Re Development at Root Farm, Dunsop Bridge
planning approval ref: 3/2021/0952

Please find enclosed on behalf of our client, The Duchy of Lancaster, a variation of condition planning application in respect to the original planning approval ref 3/2021/0952 for the redevelopment of Root Farm, Dunsop Bridge.

Enc Application form
 KL2887 / 04C (proposed site layout), 05B (proposed plans) and 06B (proposed elevations)
 Updated D&AS
 Application fee

Client	The Duchy of Lancaster		
Contract	Root Farm Dunsop Bridge		
Drawing title	PROPOSED PLANS		
Scale	1:200	Job No.	KL2887
		Dwg No.	05
			B

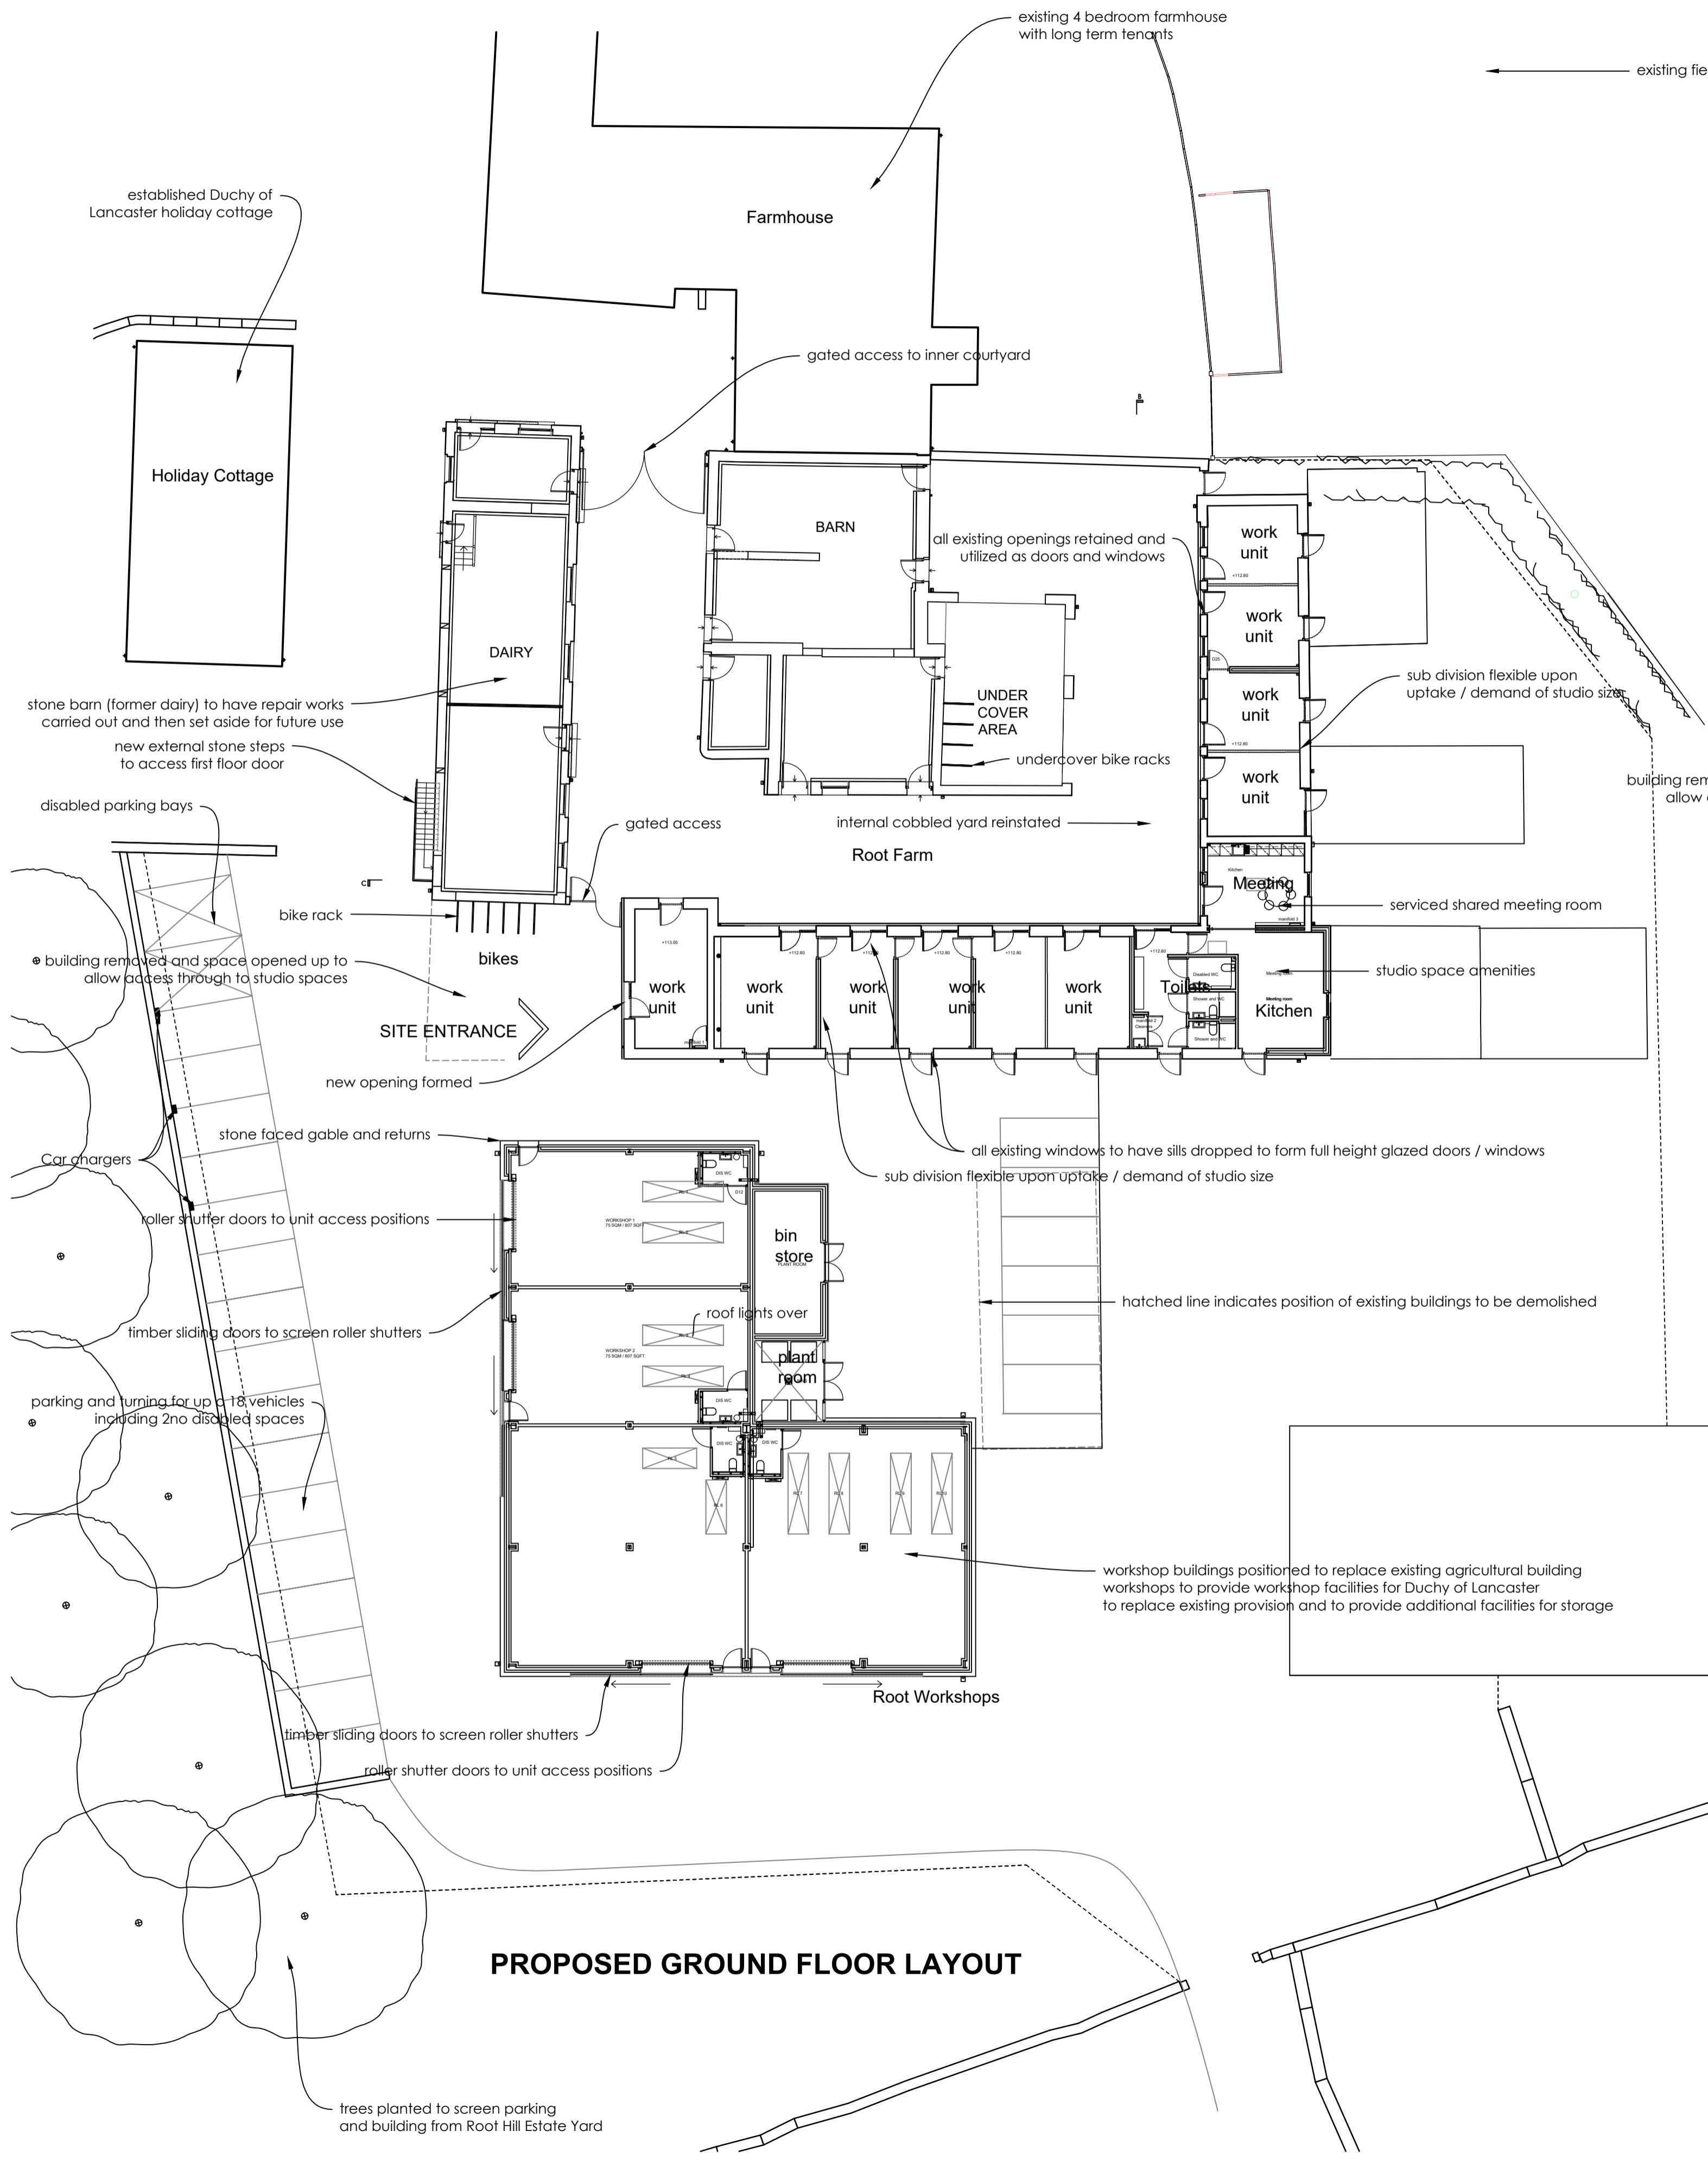
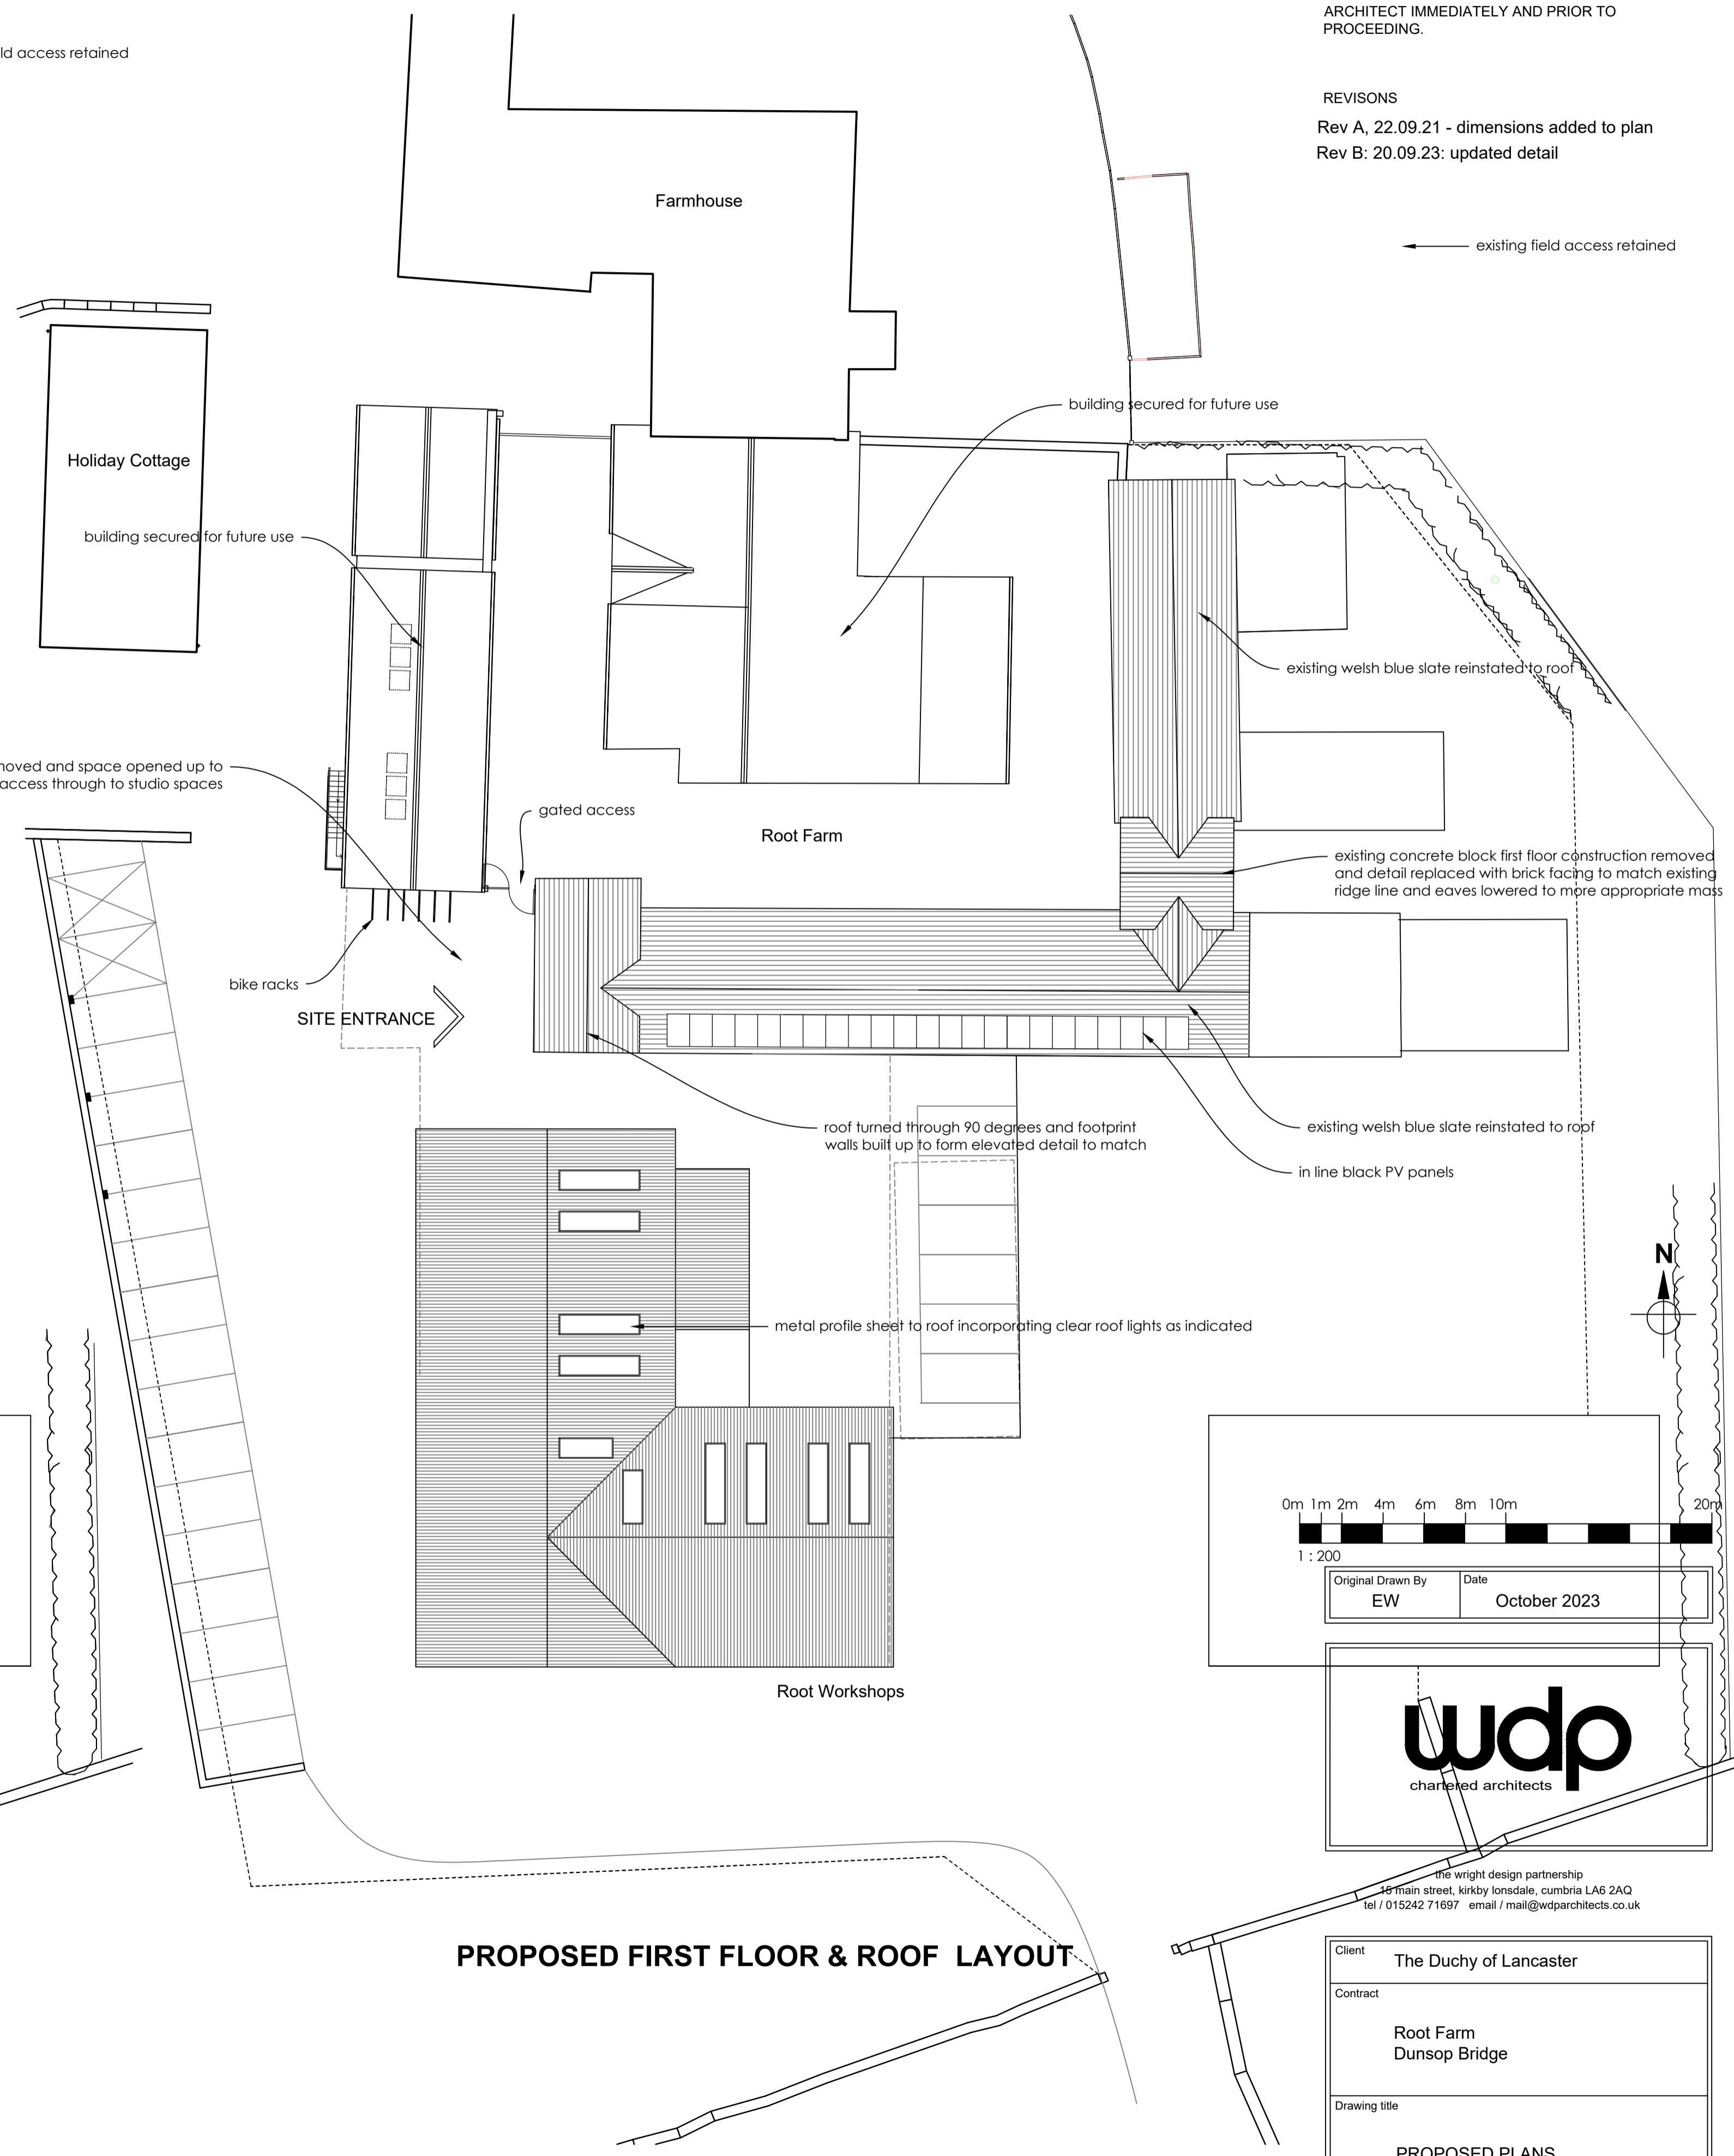
- The existing concrete buttresses to the west elevation of the dairy building are to be removed and a new external stone staircase positioned to access the existing first floor door position.
- The new build workshop units shown with stone facing to the previous exposed blockwork detail.
- The new build workshop units have had separate pedestrian doors added for ease of access without opening/closing approved sliding timber doors and roller shutter detail.
- The rooflights to the new build workshop units have been adjusted in their position but all remain on the east / north roof slopes as agreed previously.
- The bin store to the new build workshop units is proposed as open with no roof covering.
